# V3\_zone Map comment.pdf Markup Summary 3-8-2023

REZONE EXHIBIT

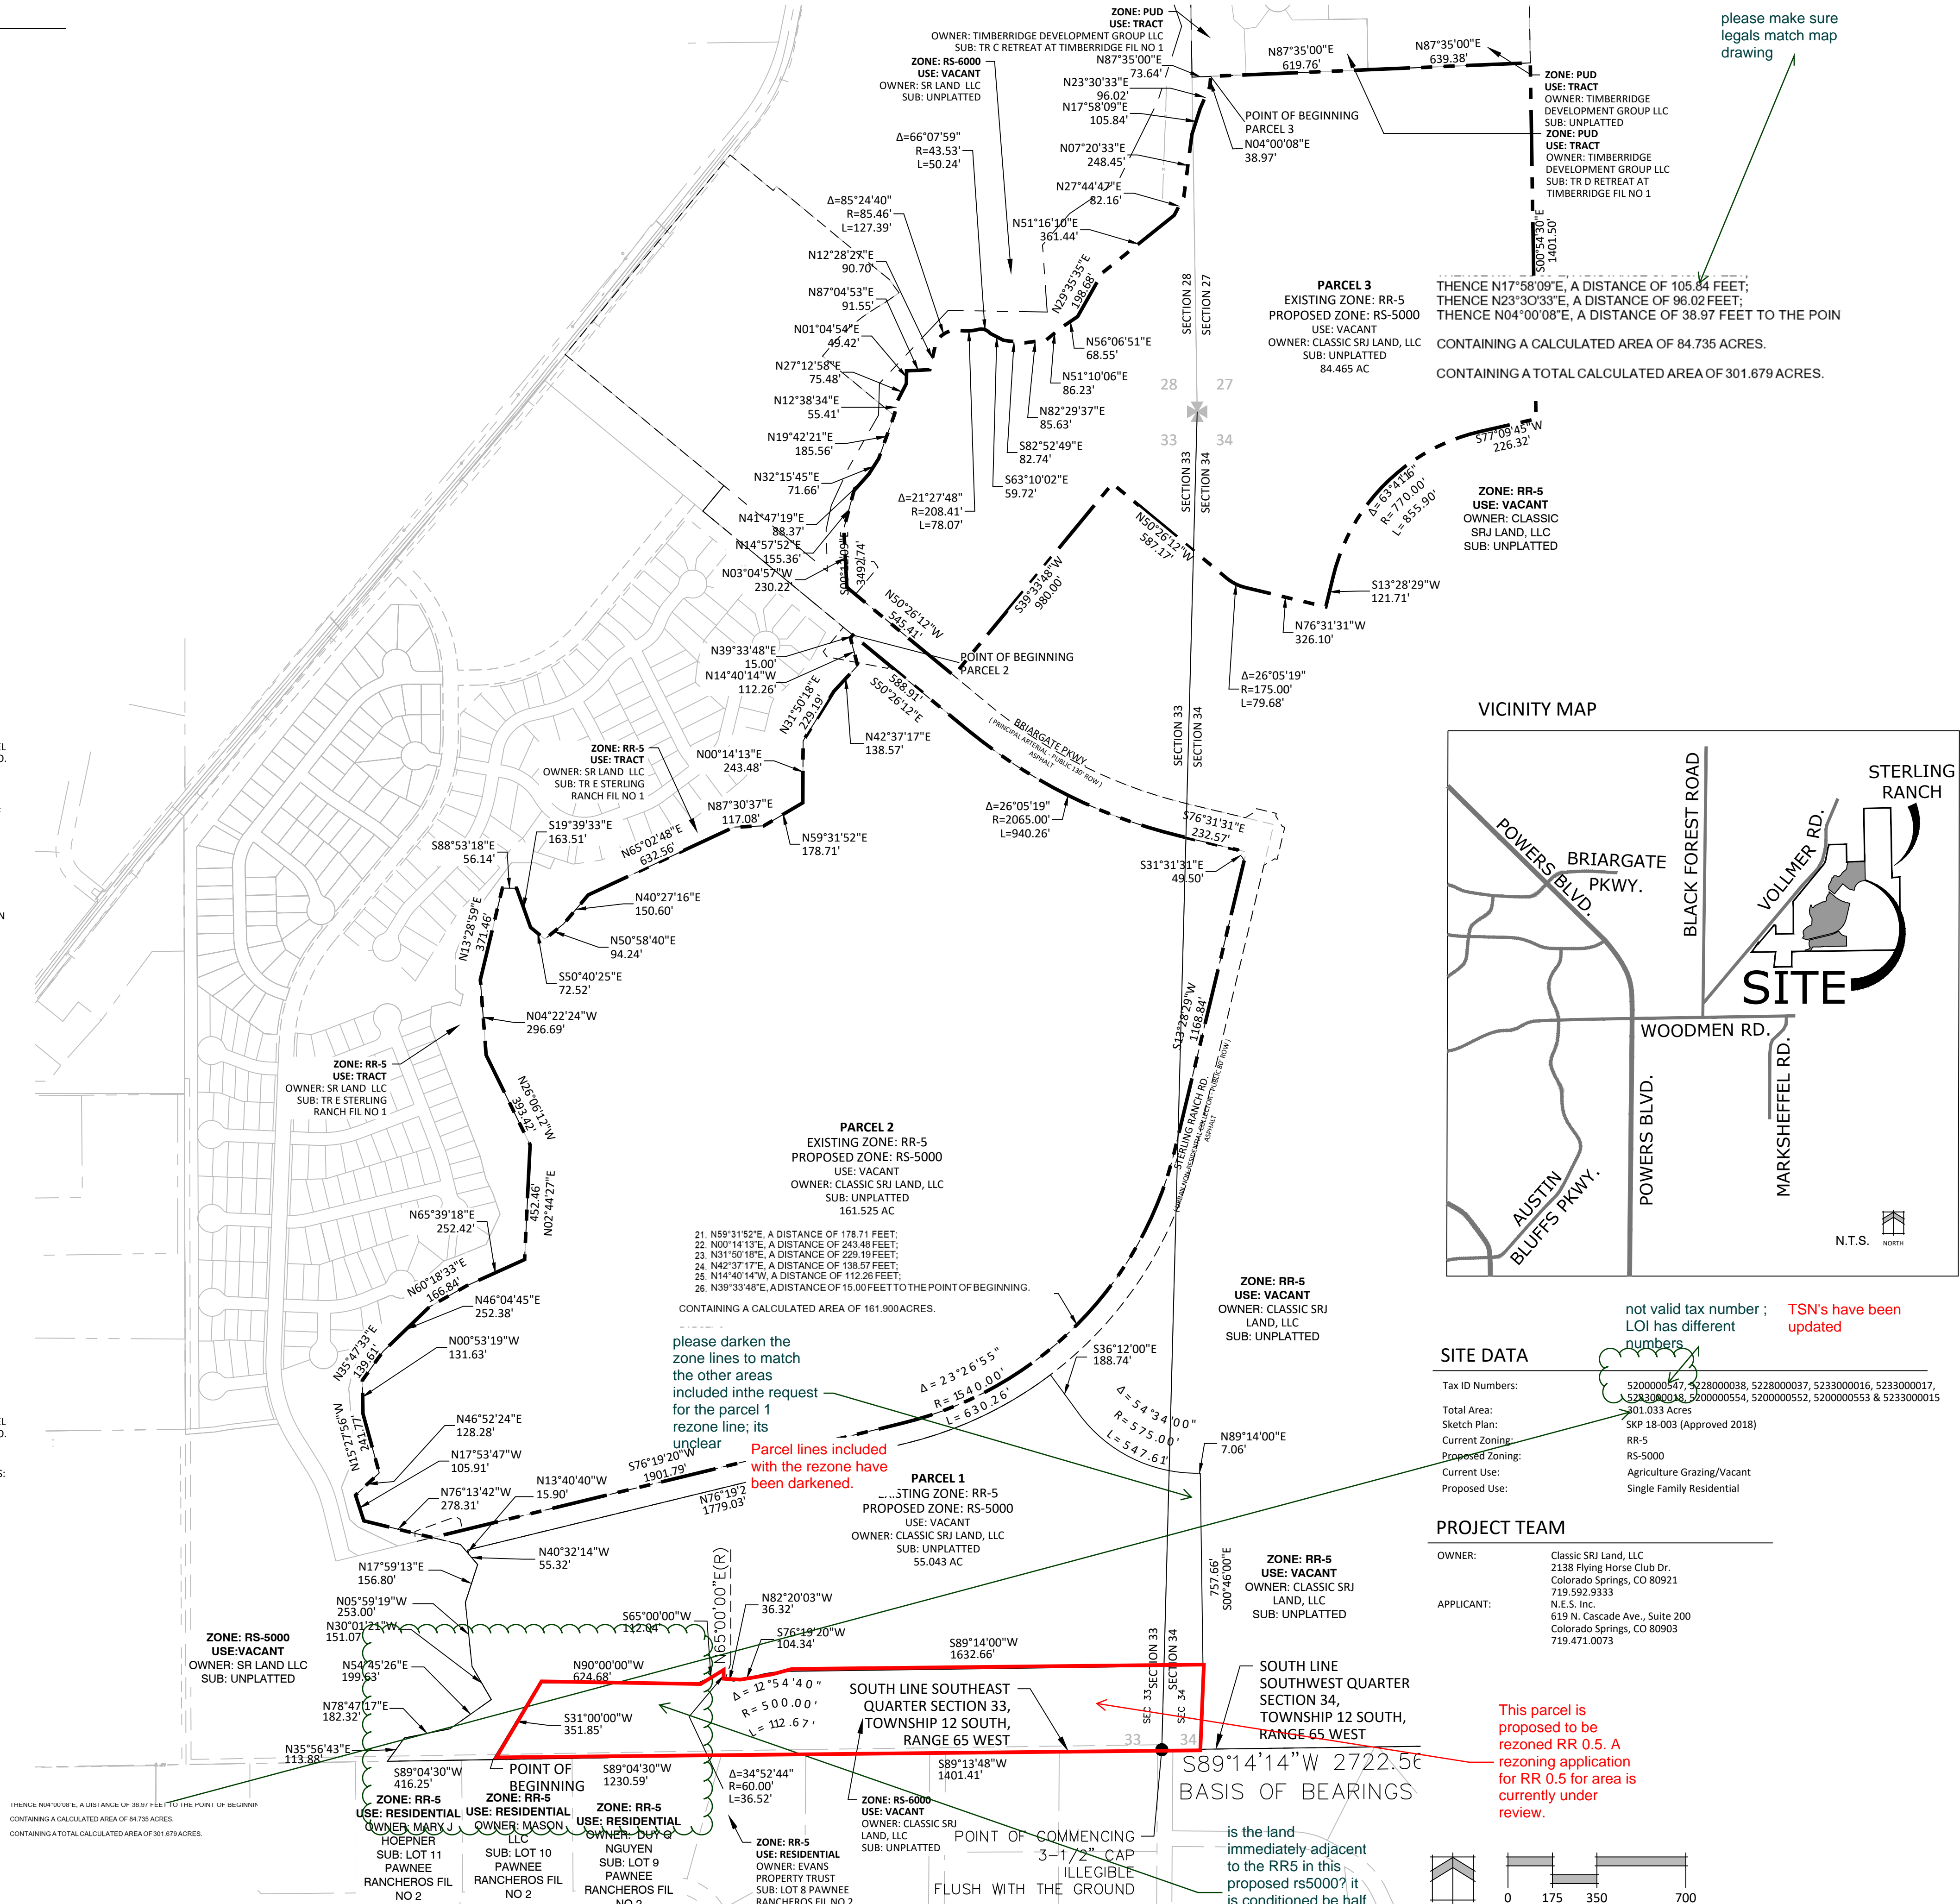
this is not correct; this is proposed to be rural (RR0.5) not urban. Existing RR5 ; proposed RR 0.5. (Not included with this rezone request)

please make it clear this is not included
